**RE: SSD-10460 – Hume Battery Energy Storage System EIS Exhibition**

I refer to your email dated 6 August 2020 requesting WaterNSW's comments on the above Environmental Impact Statement (EIS) for the Hume Battery Energy Storage System (Hume BESS). WaterNSW understands the proposal involves the construction of the BESS, works on the access track, underground cabling infrastructure, switchyard upgrades and fencing.

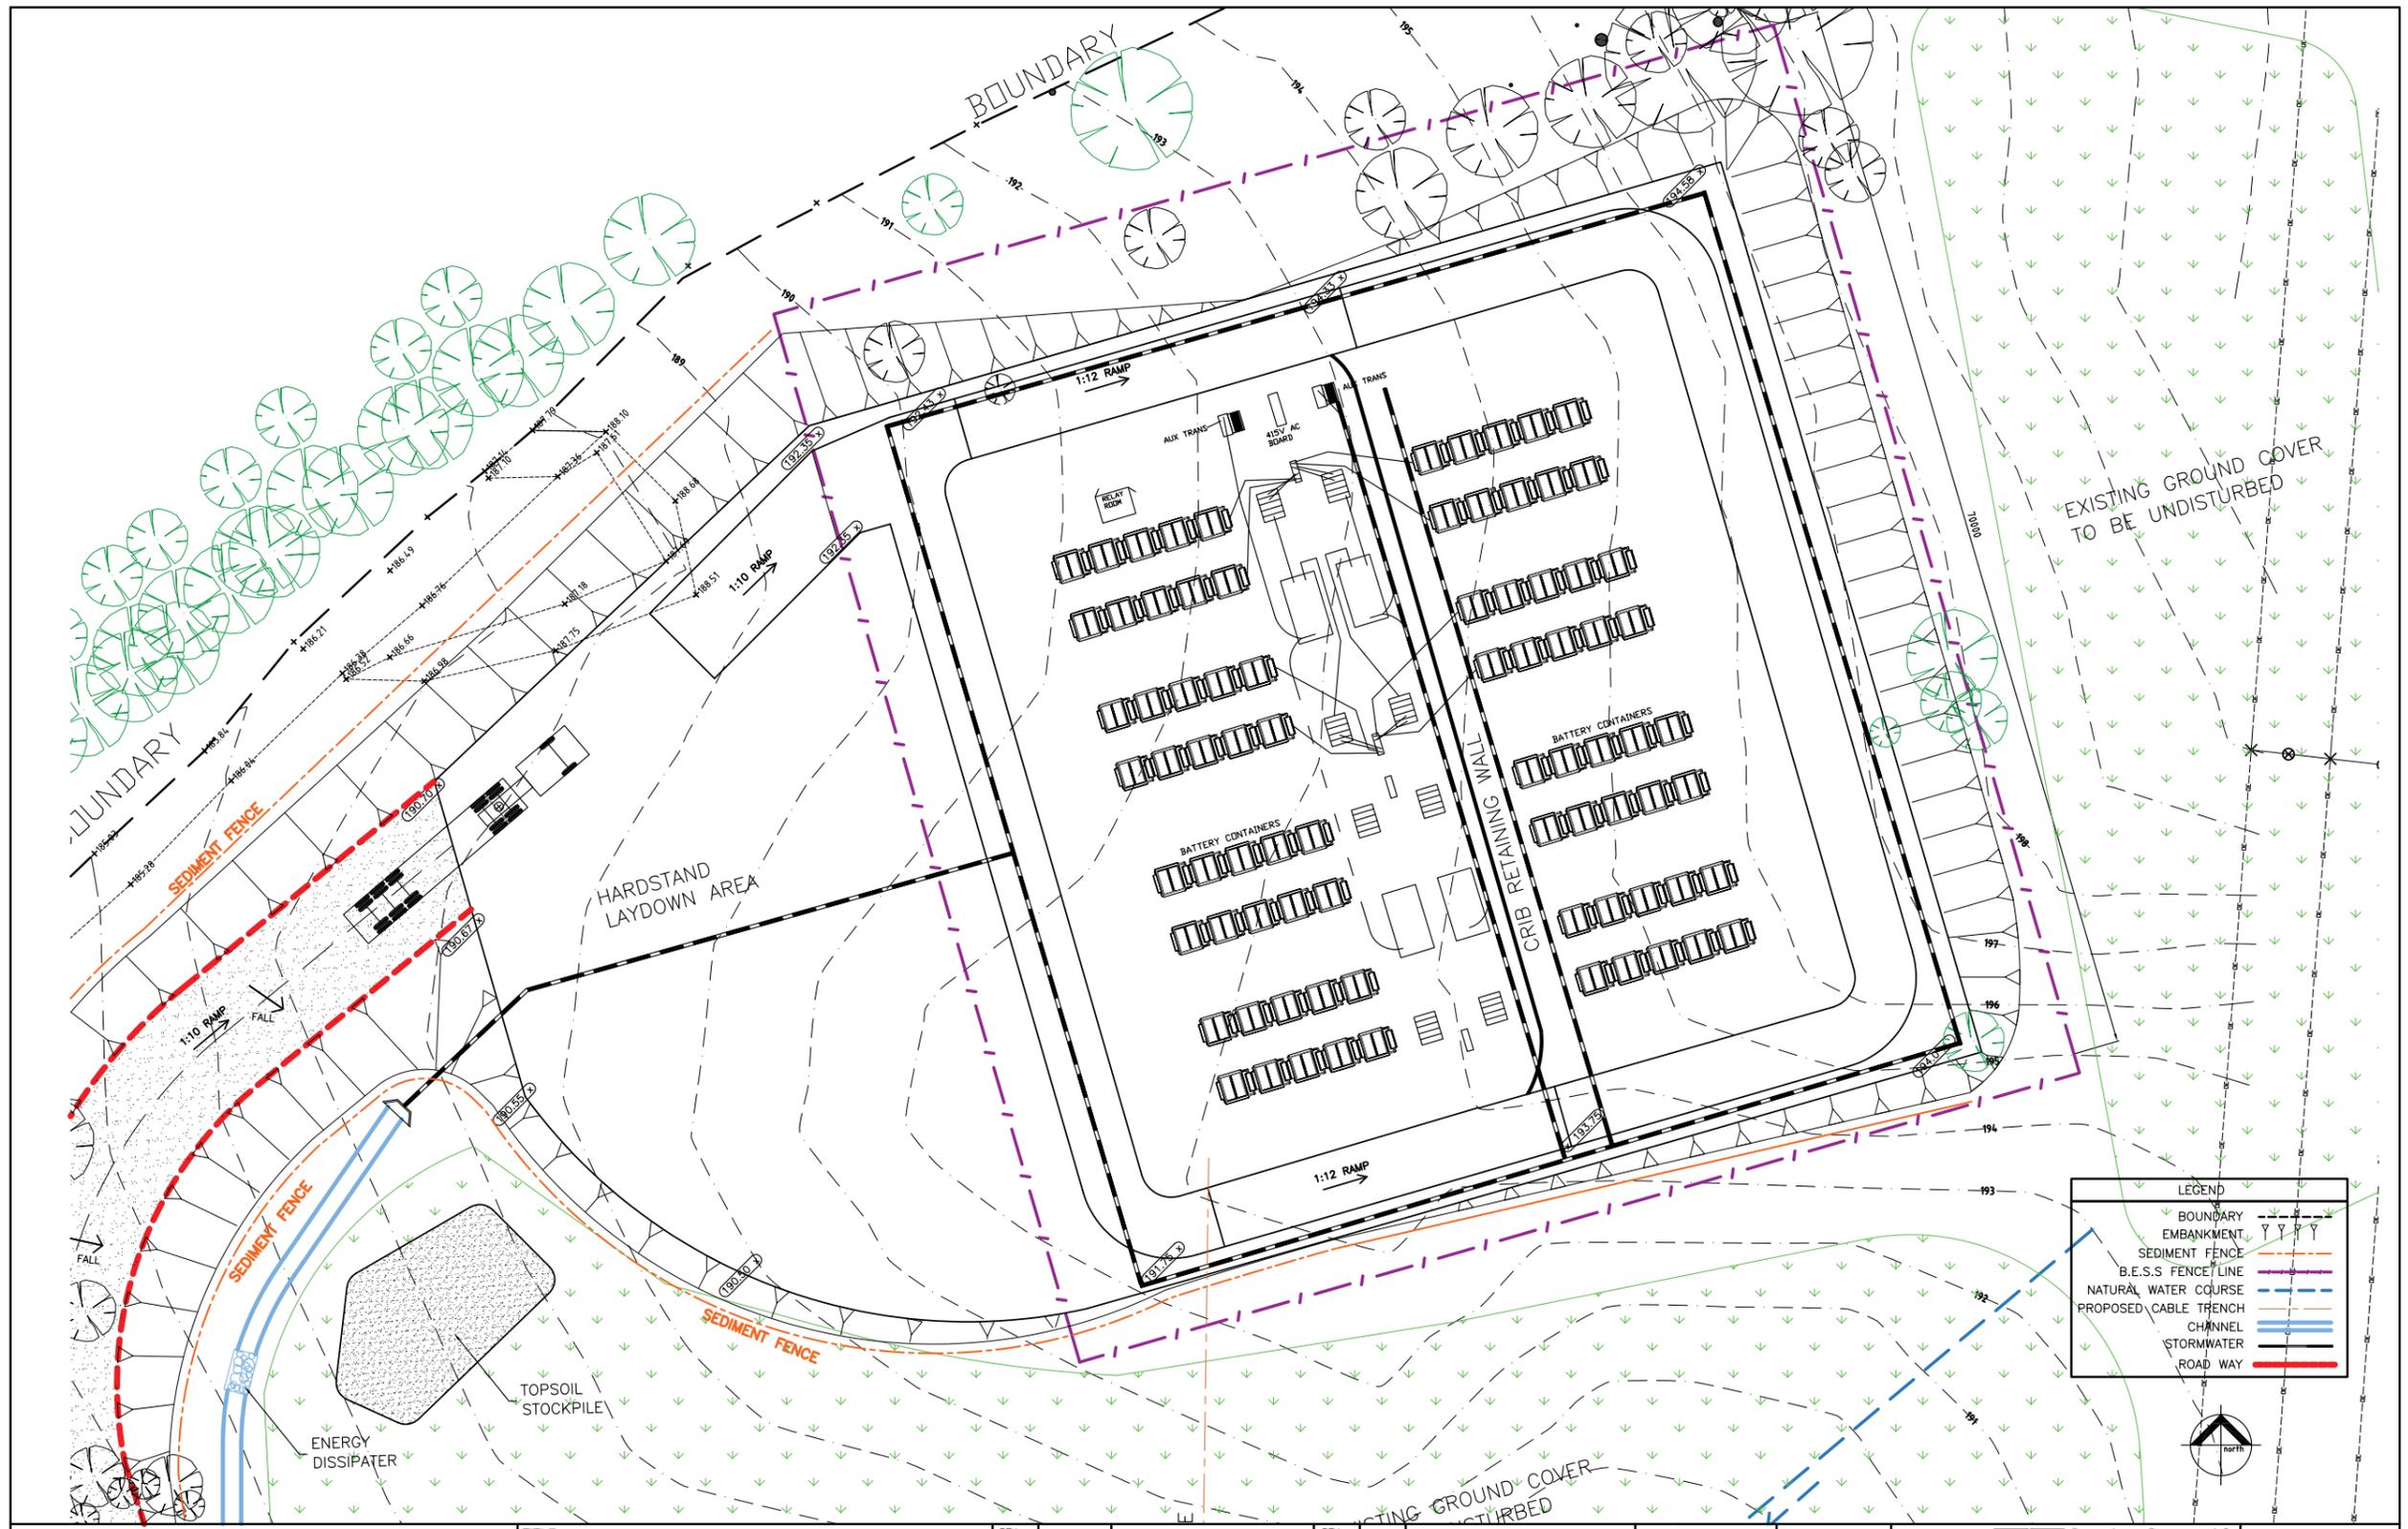
The EIS (p. xx) notes that the location of the project area downstream of the Hume Dam and Lake Hume Reservoir means it would not result in any impacts to the hydrology and water quality within the dam. However, WaterNSW notes there is a drainage line from the project area flowing to the south-west, which is identified on Figure 7-1 (p.50) and DWG S1 (TGA Engineers; Rev 0; dated 26/06/20) of the Design Drawings in Appendix C.

The location of the drainage line, its proposed modification (including a culvert and armouring), and its incorporation into the stormwater management for the project area, may result in impacts to the identified terrestrial wetland on WaterNSW land into which it drains. WaterNSW understands, through consultation with Meridian, that the Design Drawings are preliminary and a detailed design, including for soil and water management, will developed.

In order to prevent impacts to the wetland and water quality leaving the site during construction and facility operation, the stormwater flows from the project site post-development must not be greater than pre-development. The direct and indirect impacts on the catchment area, including

changes to the pervious area as a result of the project (including the proposed access road) must be taken into account. Appropriate and adequate stormwater management measures and erosion and sediment controls must be incorporated to ensure water quality is also not impacted.

- *Post-development stormwater flows must not exceed pre-development flows, for both water quality and quantity.*
- *A Soil and Water Management Plan (SWMP) must be developed and approved by WaterNSW before commencement of establishment or construction works. The SWMP must include controls for all aspects of the project, including the proposed access road, stockpile site, batters, and trenching to the switchyard, as well as the battery site.*
